Response to Planning application from Hertfordshire County Council (T and CP GDP Order 2015)

District ref: 6/2020/1463/FULL
HCC ref: WH/2479/2020
HCC received: 12 August 2020
Area manager: Matthew Armstrong
Case officer: Paul Marshall

1 MAYNARD PLACE CUFFLEY POTTERS BAR EN6 4JA

AMENDED PROPOSAL

DRAWING NUMBER:	REV:	ISSUED BY:
1254.01.001		CF

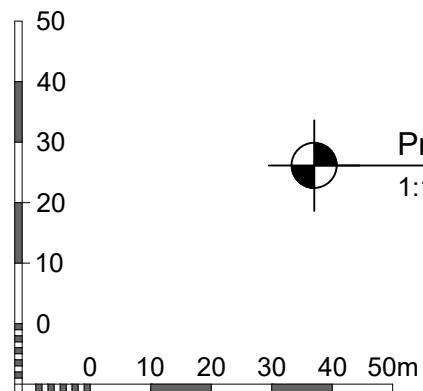
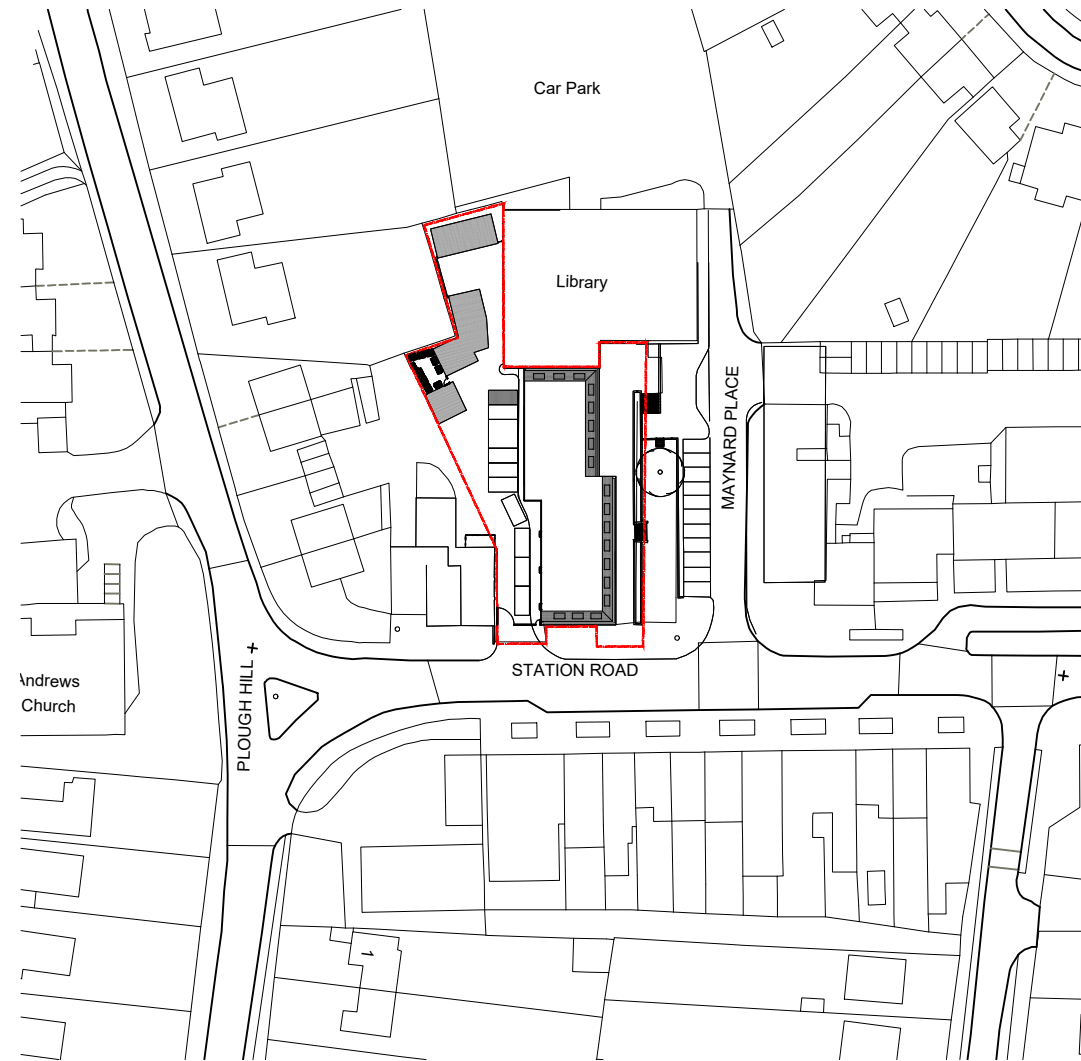
Drawing 2000460-001 Rev B outlines swept path for parking. In my previous comments Drawing 1254.01.001 demonstrated an unsatisfactory form of car park layout. The accessibility demonstrated by the swept path analysis is substandard with up to 4 manoeuvres required for some of the parking bays and garages, having said I accept the larger vehicle (4.572m) used for the analysis, also that it is not a point to refuse on.

The transport consultant states: 'The proposals are to utilise the existing spaces and garages rather than provide a new reconfigured car park'. As the development is fundamentally changing the site, I do not accept that the existing substandard parking is acceptable. In my previous comments I stated parking bays 1 to 4 do not comply with Manual for Streets 8.3.48 which states 'For parking parallel to the street, each vehicle will typically need an area of about 2m wide and 6m long', this is still an issue, most especially with parking bay 1 with the introduction of gates.

- a) sub-standard parking (bays 1-4),*
- b) no boundary information,*
- c) no detailed design of the proposed gates,*
